REQUEST

Proposed Zoning: MUDD-O (mixed-use development, optional)

Approximately 7.0 acres located on the northeast corner of Prosperity Church Road and Old Ridge Road.

The petition proposes to allow 79 single-family attached residential units, 15,000 square feet of commercial uses, and a remote drive-through service terminal for a financial institution.

RZ-1

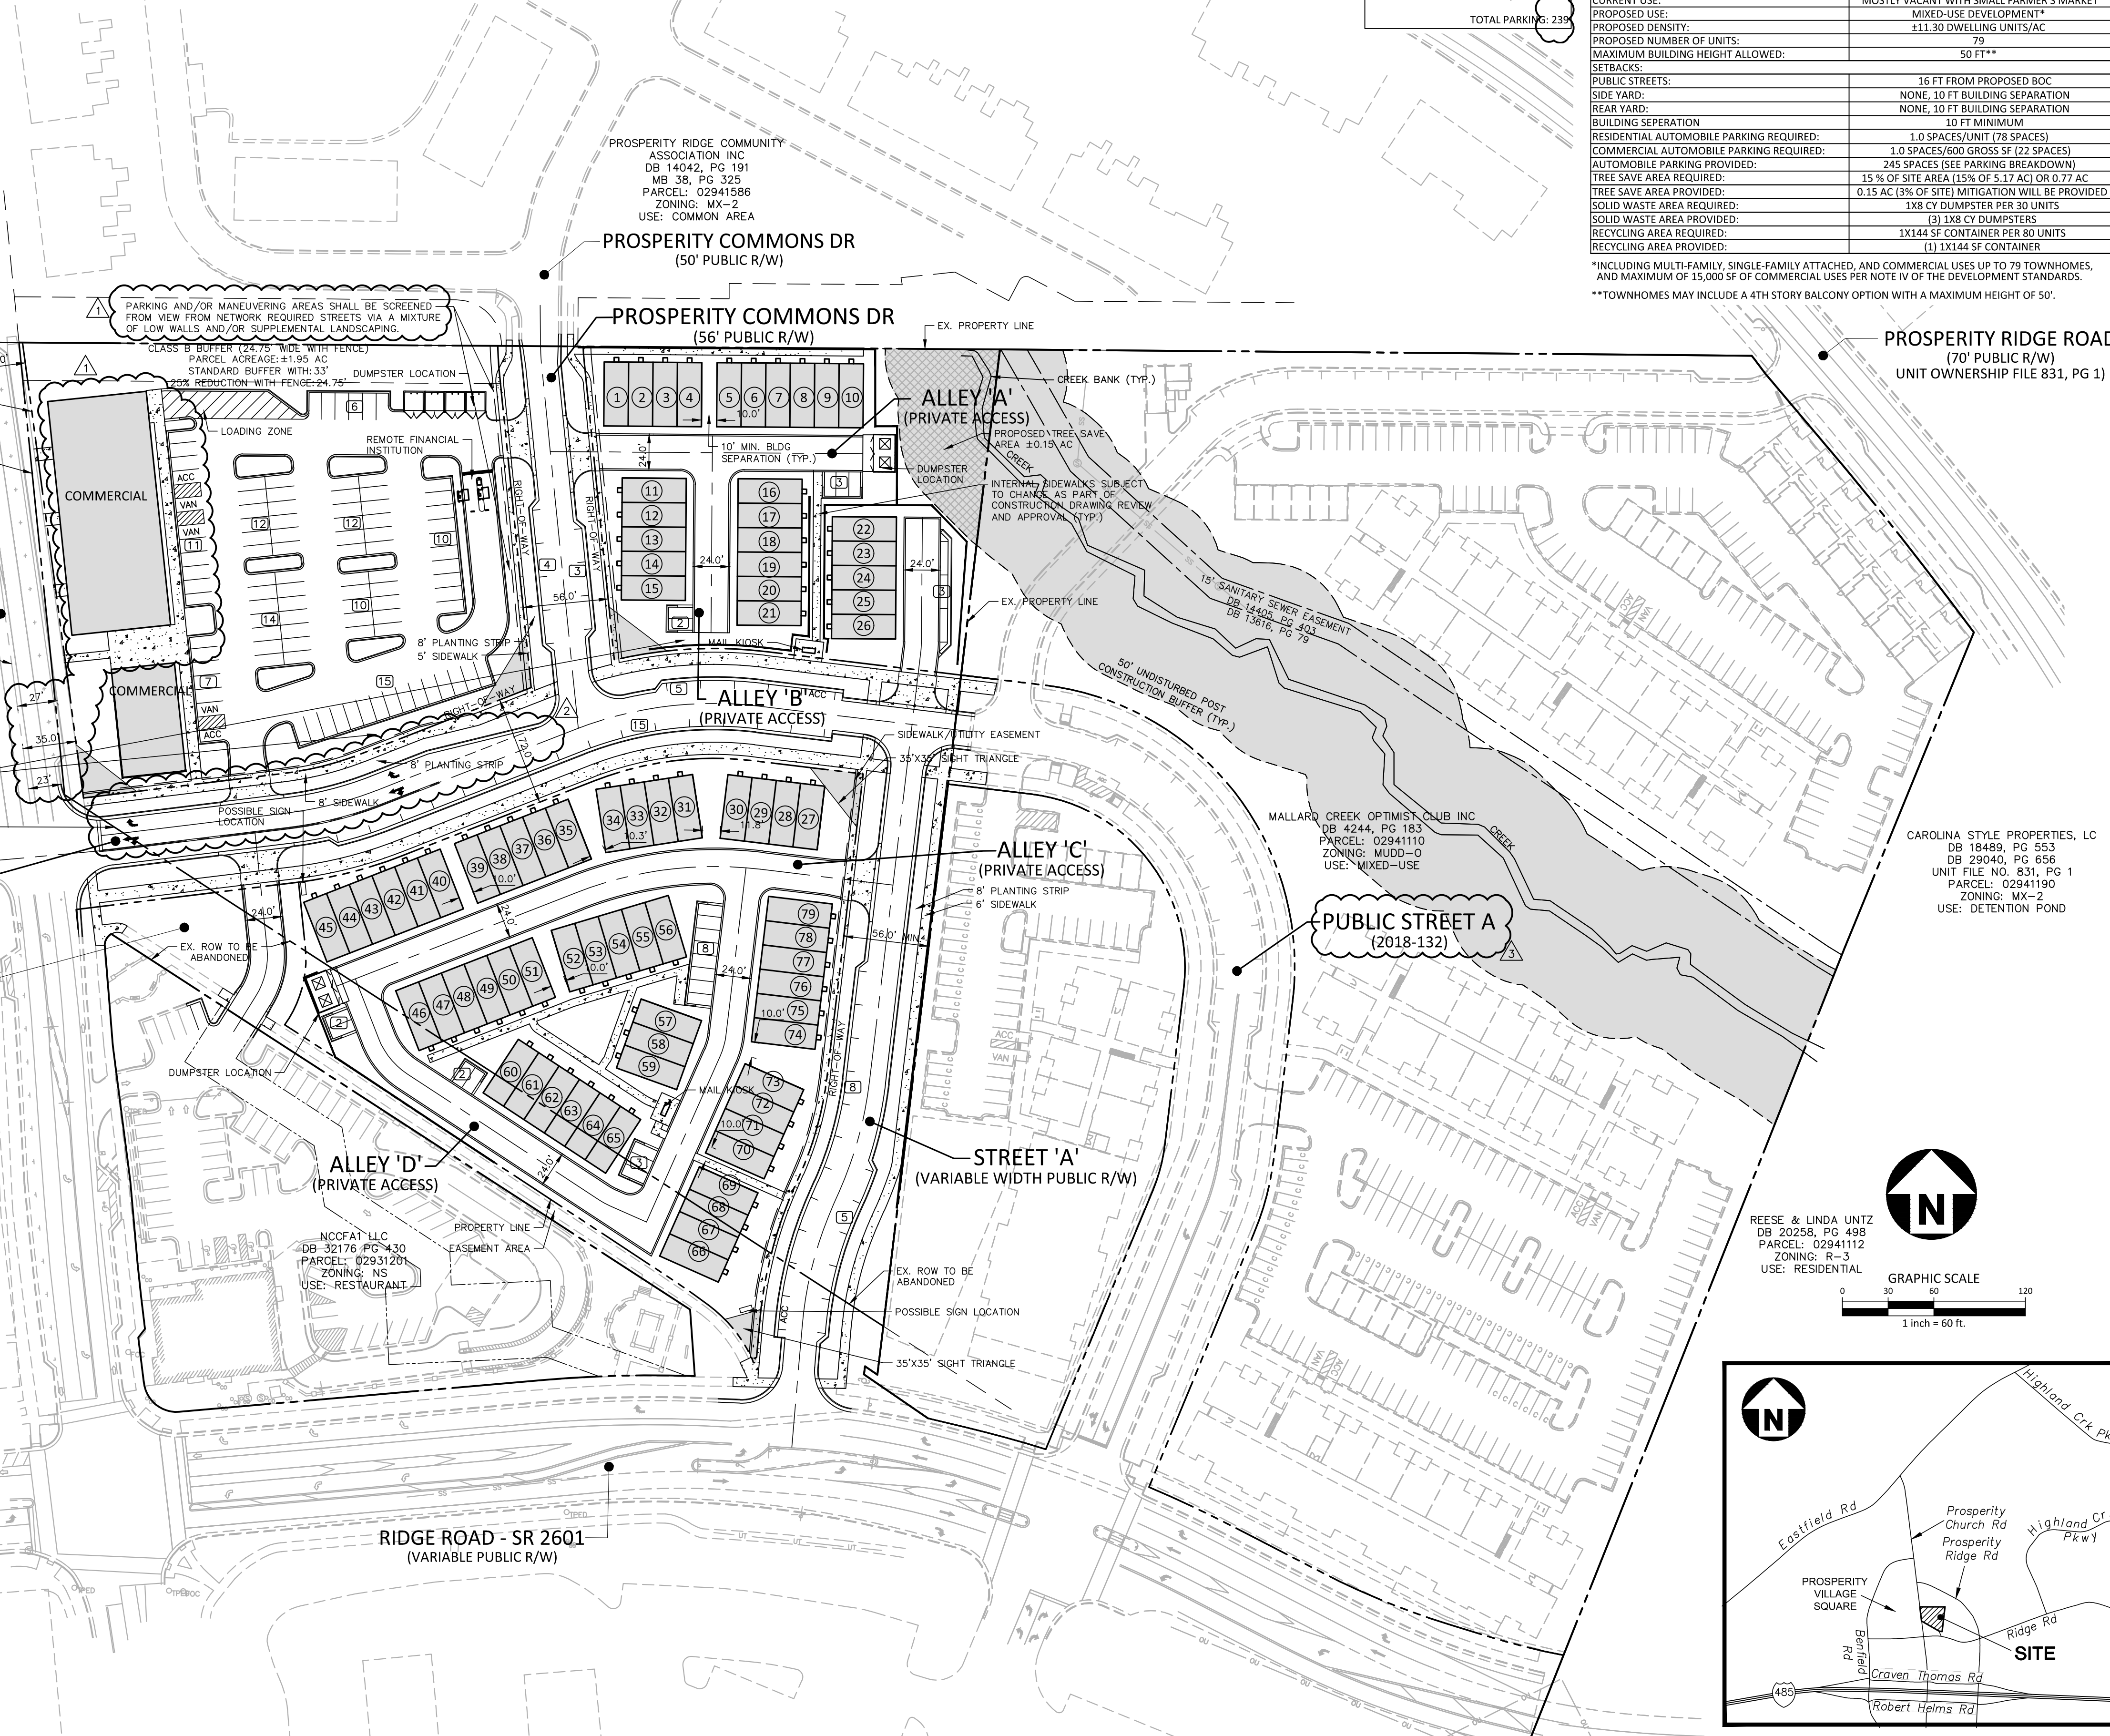
1. ~~The petitioner should revise the site plan and conditional note(s) by removing the note stating the curb and gutter along Prosperity Church Road will be constructed by the City project. The petitioner should commit to construct the required ordinance curb and gutter requirement and streetscape along its frontage of 8-foot planting strip and 6-foot wide sidewalk.~~ **Addressed**
